Dogger Bank South Offshore Wind Farm

**Appendix H2 to the Natural England Deadline 2 Submission**  
**Natural England's comments and advice on Offshore Ornithology Compensation**

Planning Inspectorate Reference EN010125

27<sup>th</sup> February 2025

Legend:

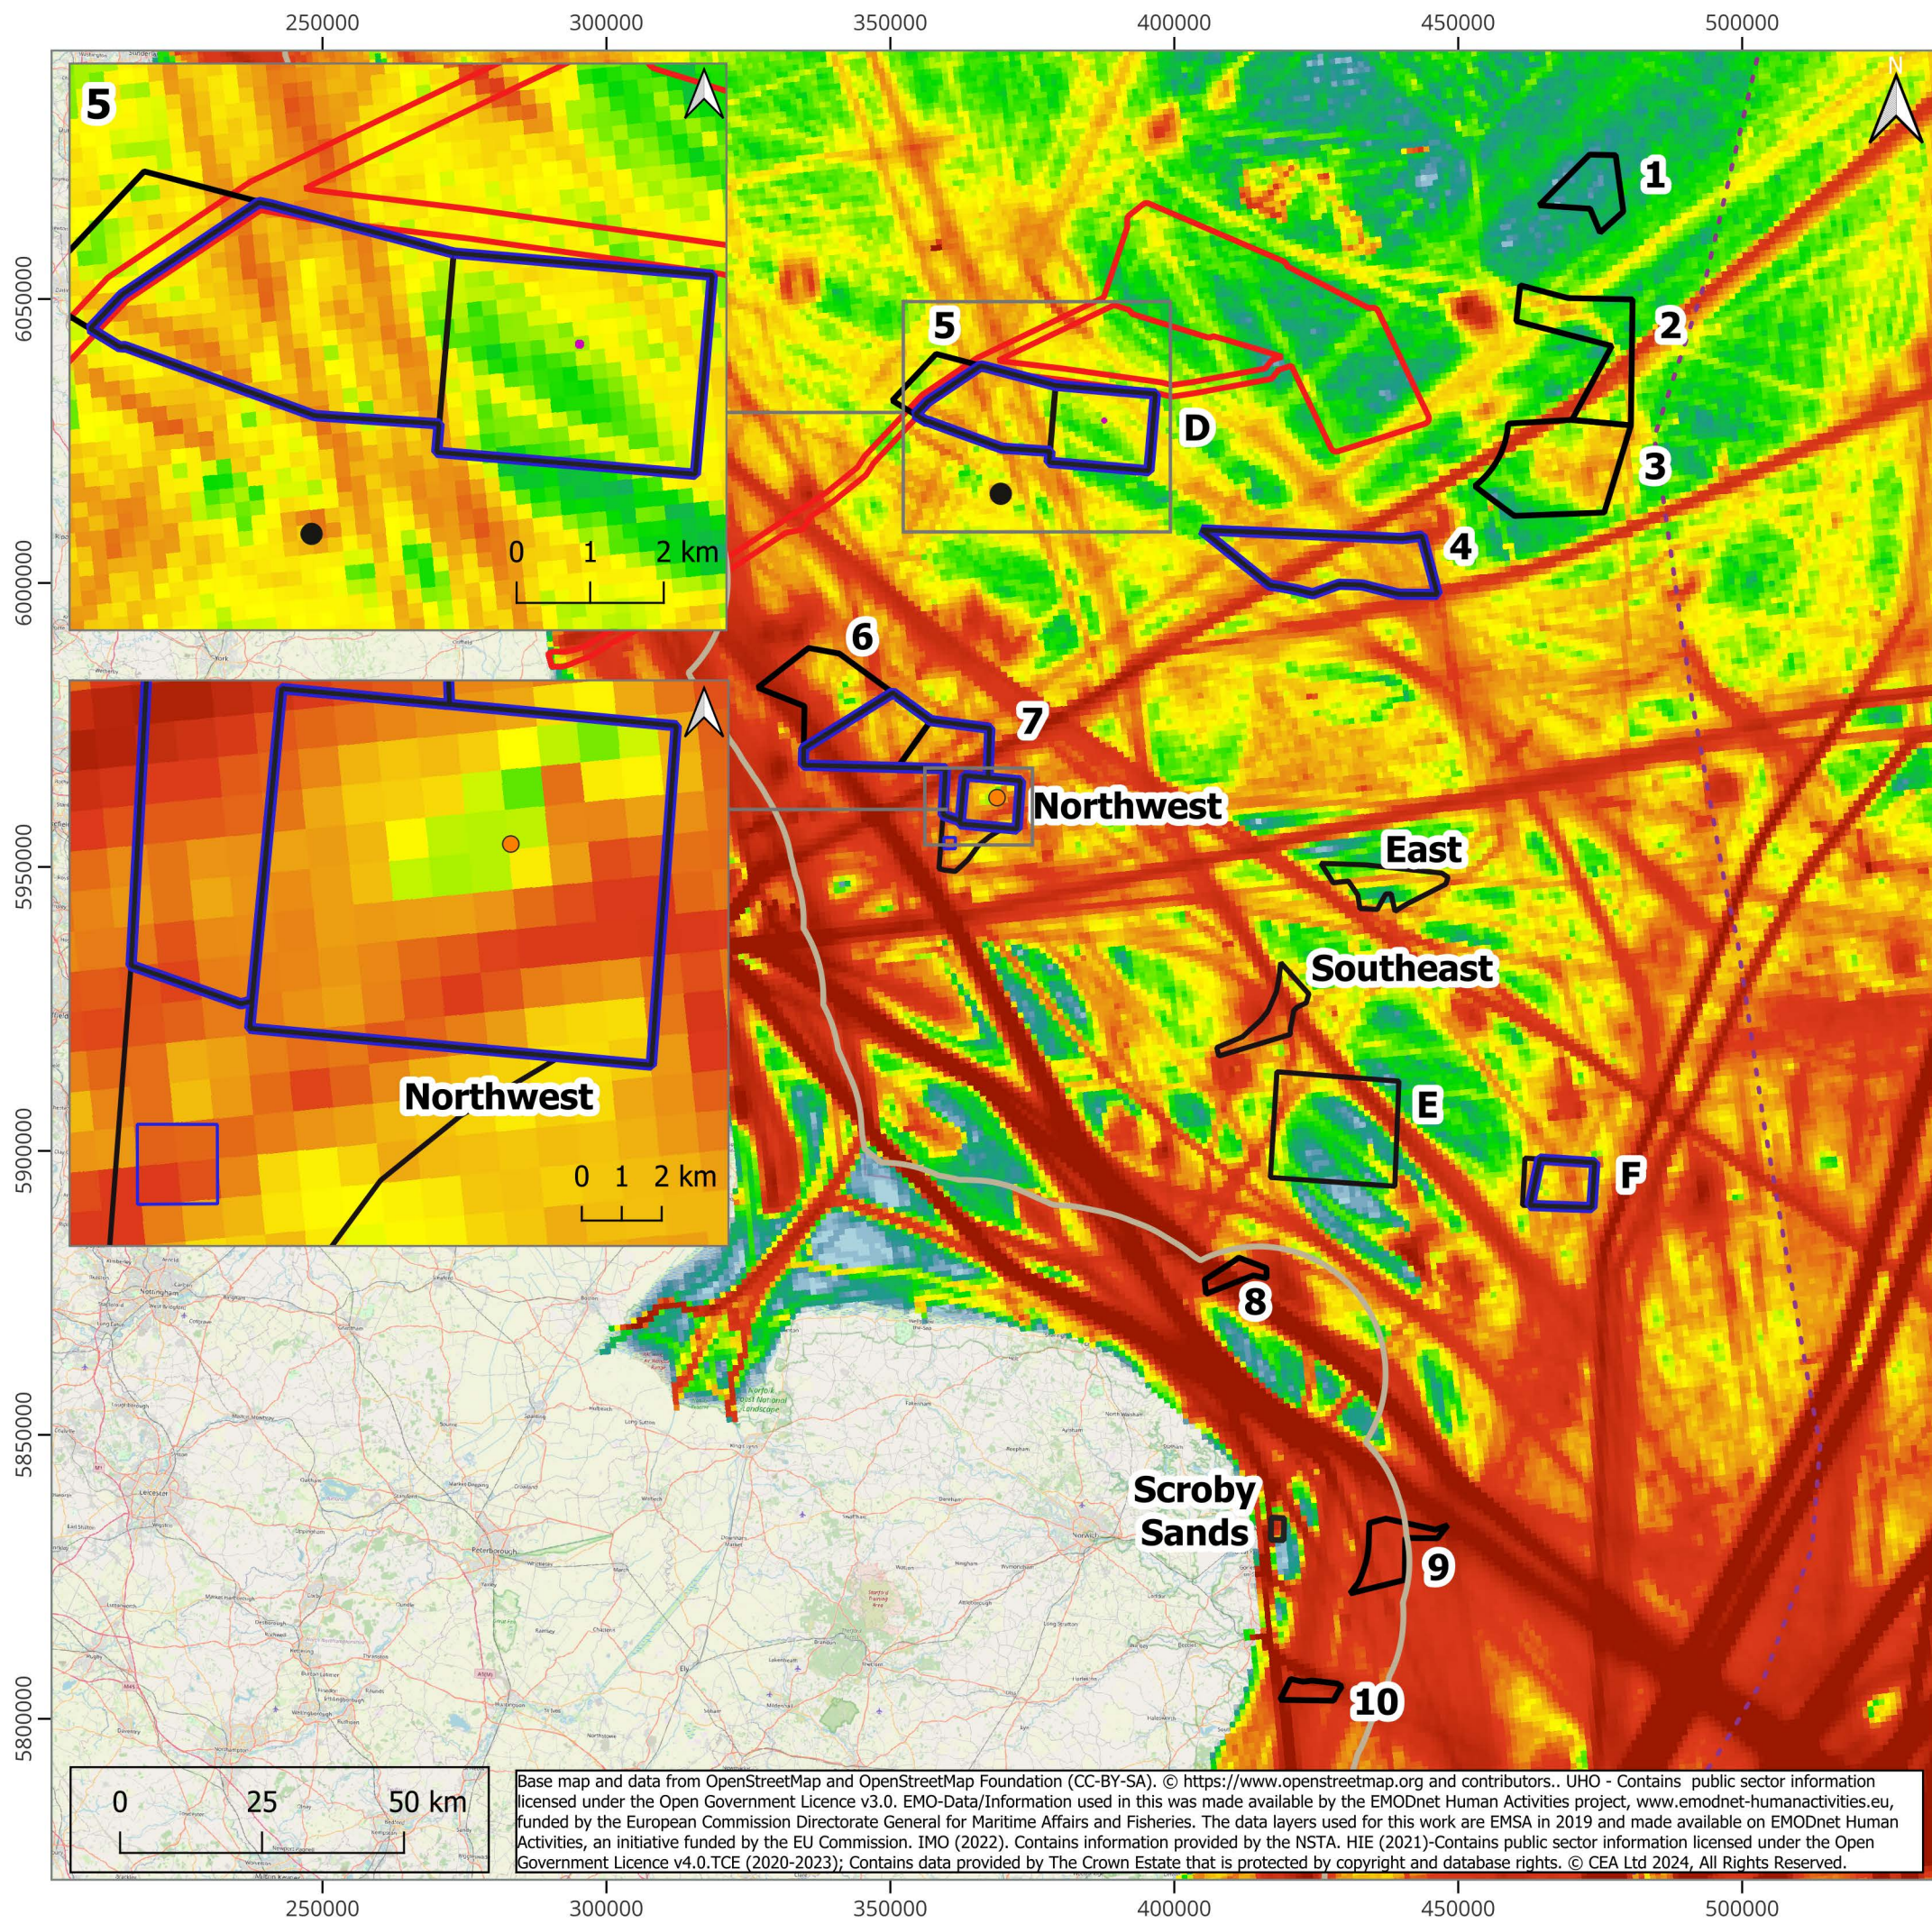
- Site F - We welcome that the area that overlapped with the North Norfolk Sandbanks and Saturn Reef (NNSSR) SAC has been removed from the Area of Search.
- Sites 4 and 5 - As per our Relevant Representations advice, we highlight that these sites appear to be within the buffer zones for DBS and the Hornsea Zone offshore wind farms (OWF). Consideration should be given to a greater degree of collision risk for a colony established here.
- 6, 7 & North-West - These locations are not as far inshore as the original 'West' location, however consideration should still be given to the likelihood of competition with birds foraging from FFC SPA. We advise the Project to look into any overlap with these areas in available kittiwake utilisation distribution maps (e.g. Cleasby et al. 2020, Waggitt et al. 2020). For site

6 it would also be beneficial to present the minimum distance to Flamborough Head, for consideration of the Yorkshire Wolds AONB.
